**FW: Morrisons, High Street, Yiewsley - 2370/APP/2018/2793 [NLP-DMS.FID469124]**

**From:** Richard Phillips <rphillips@hillingdon.gov.uk>**Sent:** 21 November 2018 16:10**To:** Philip Trueman <ptrueman@hesterarchitects.co.uk>**Cc:** Hannah Young <hannah.young@lichfields.uk>; Andrew Rennie <AndrewRennie@citygrove.com>; Mandip Malhotra <mmalhotra@hillingdon.gov.uk>; Ali Kashmiri <akashmiri@hillingdon.gov.uk>**Subject:** Morrisons, High Street, Yiewsley - 2370/APP/2018/2793

The proposal to demolish the existing Morrison supermarket in Yiewsley, and to construct a new store with 144 residential units above, has been assessed with reference to the requirements of London Plan (2016) policy 3.8 and 7.2. Reference has also been made to the Council's Supplementary Planning Document 'Accessible Hillingdon' (adopted September 2017), in setting out the following observations:

Drawing Title
**Proposed Basement -1 Floor
Plan**

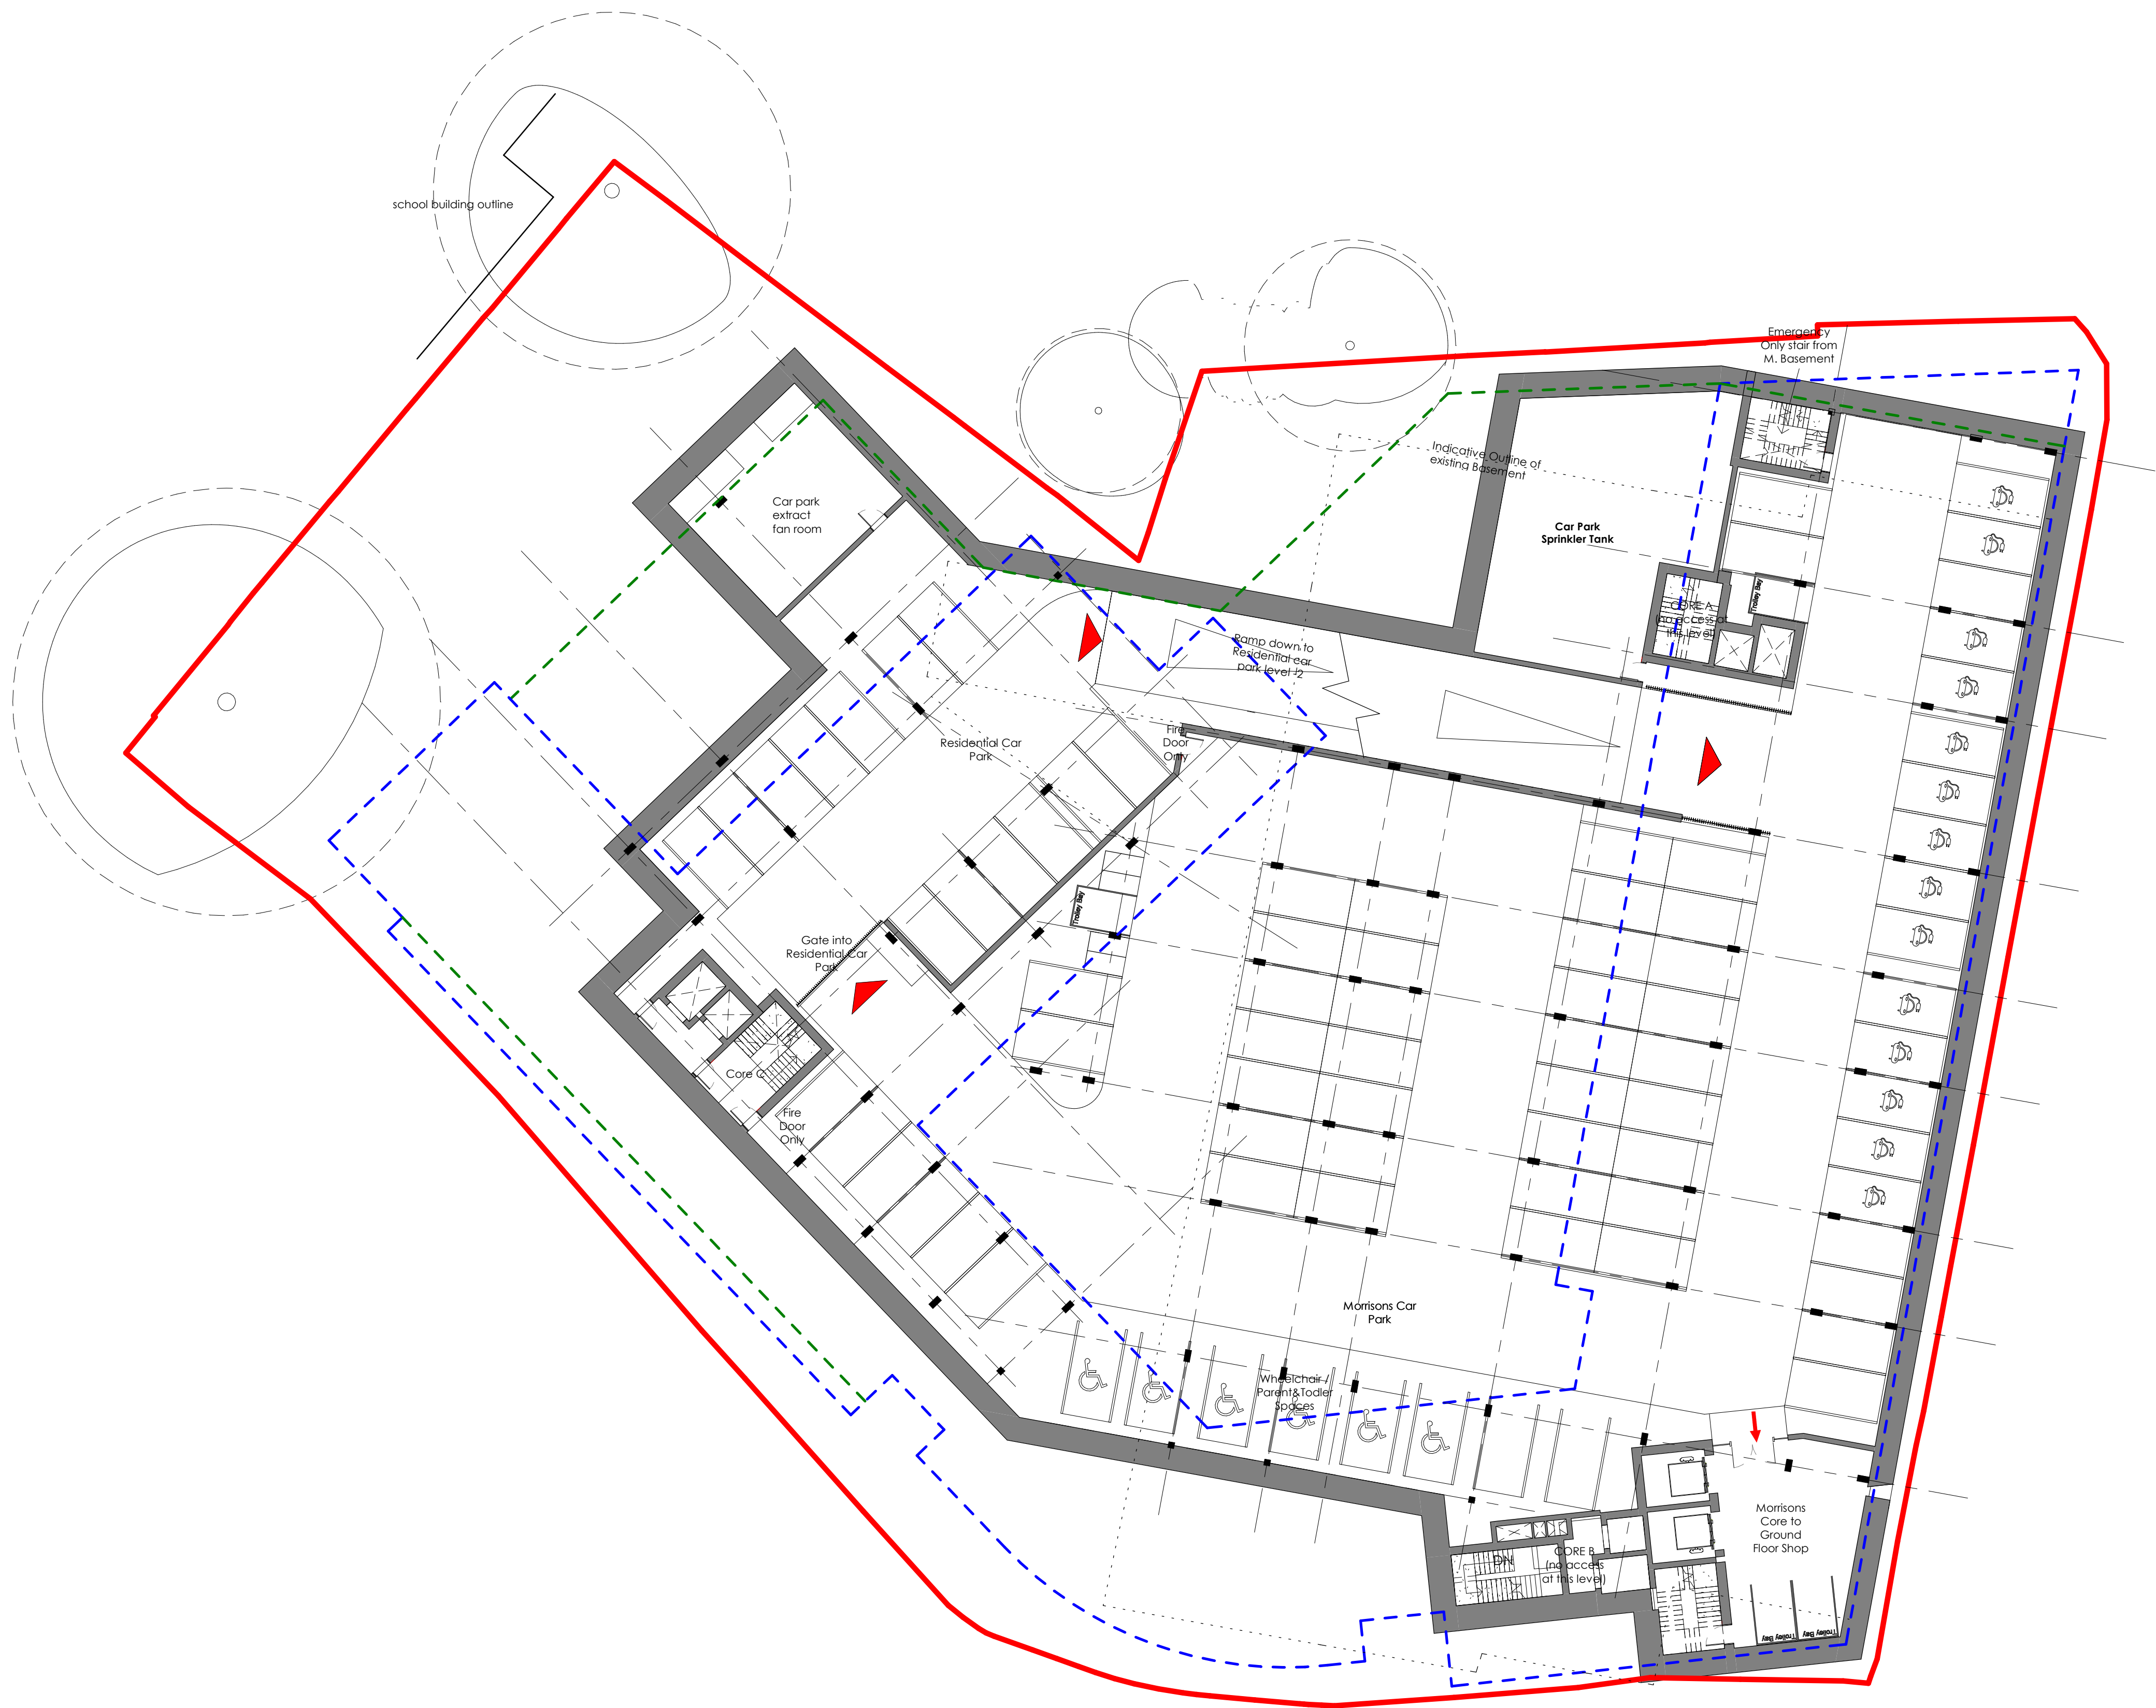
2. The vertical height clearance into and within the proposed basement car park levels is shown at 2.1 m, which would not allow the passage of a high top accessible vehicle. Any vehicle height barrier should provide a vertical clearance on level ground of 2.6 m from the carriageway to allow high sided accessible vehicles to enter, manoeuvre within, and exit the car park. As a minimum, the vertical clearance of 2.6 m should be maintained from the entrance of the car park to the designated accessible parking spaces and exits from those spaces, in accordance with BS 8300-1:2018. **We confirm that we have 2.9m minimum clearance on the upper level of basement and 2.6m clearance on the lower level.**
